From: [REDACTED]
Sent: [REDACTED] 14/41
To: [REDACTED]
Subject: AW/146/13/T - 2 no. Maple treest , ditch to rear of 23 Fernhurst Gardens, Aldwick

From: Janice Chapman
Sent: 31 July 2013 13:45
To: [REDACTED]
Subject: RE: AW/146/13/T Reduce the crowns of 2 Field Maple trees by 4 metres - Ditch to the rear of 23 Fernhurst Gardens Aldwick PO21 4BA

SKETCH.

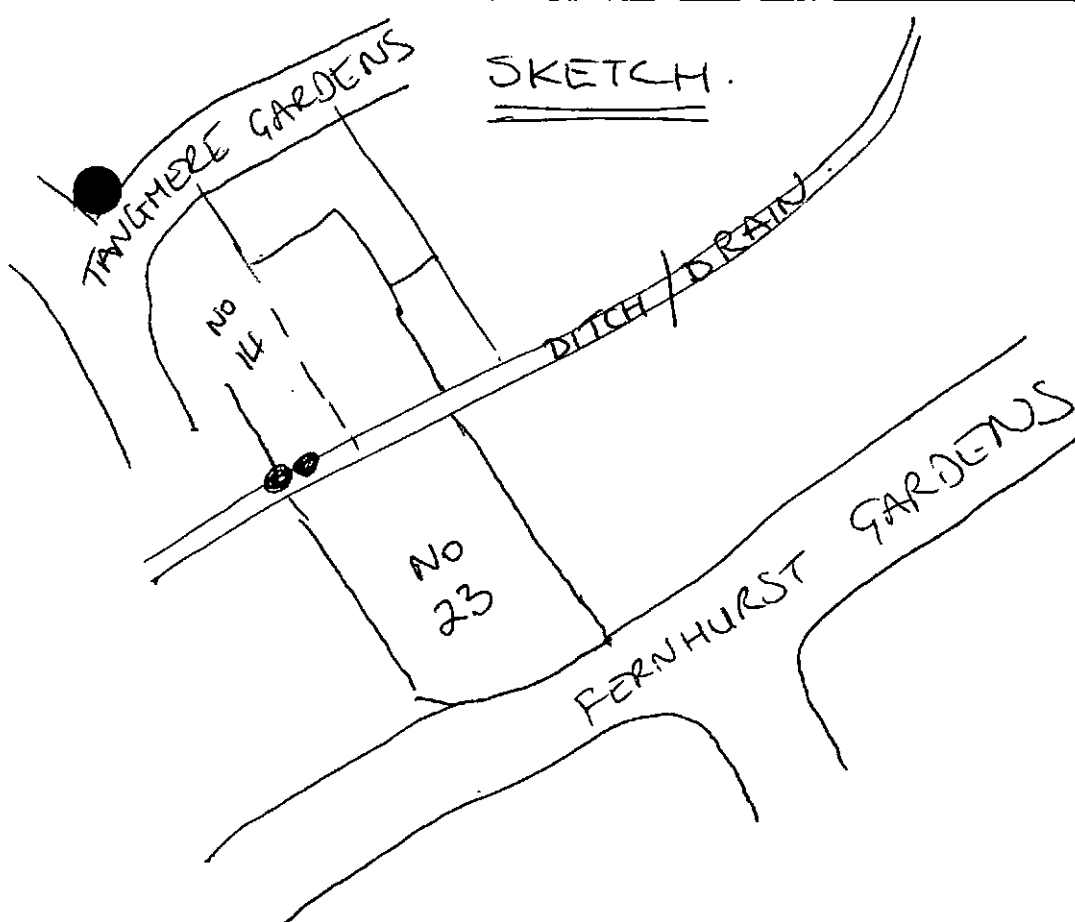
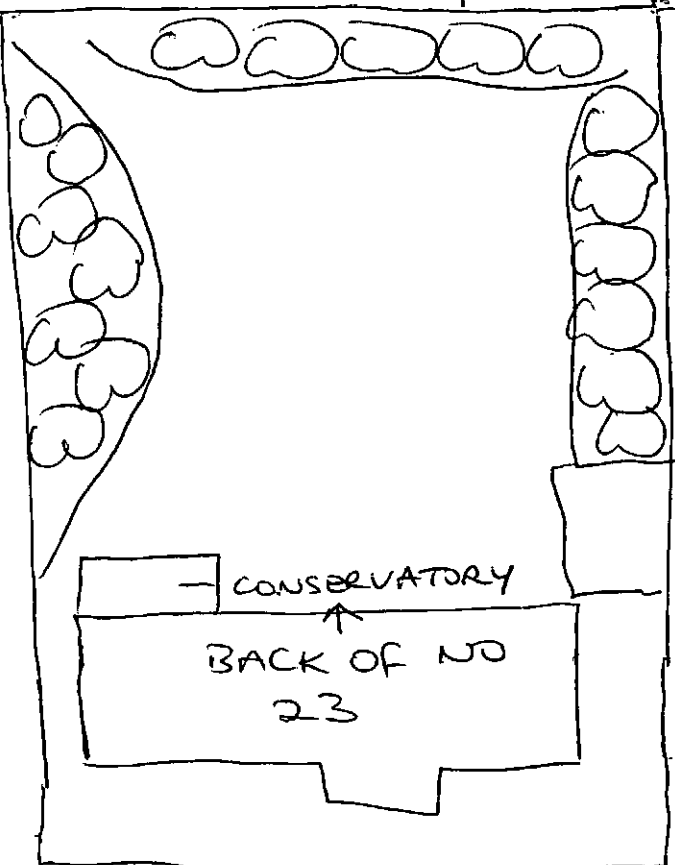
1. In lowering the proposed height reduction from 4m to 2.5 m, can we shape the lateral spread of the trees by the same amount of 2.5 m to try and minimize the light restriction we are currently experiencing? In their current height and width we are almost fully shaded in our entire garden, by late afternoon..
2. Can this work be done with an electric pruning saw or is Mr Brewster recommending that this is with a manual saw? I am concerned that if this is a manual saw, the cost of having the work undertaken will be greatly increased.

I attach recommendation from the Council's Arboriculturist in relation to the surgery to the two Field Maple trees. If you are happy to accept his recommendation then the application can be approved after its advertising period has expired which is the 13th August 2013.

I have spoken to Mr Brewster regarding your previous e-mail of 31.7.13. He has advised that a crown reduction of 2.5m with shaping to a maximum of 2.5m is acceptable and he has raised no objection to the use of an electric pruning saw. In view of his comments I will amend the description on the application and you should receive a decision within the next few days.
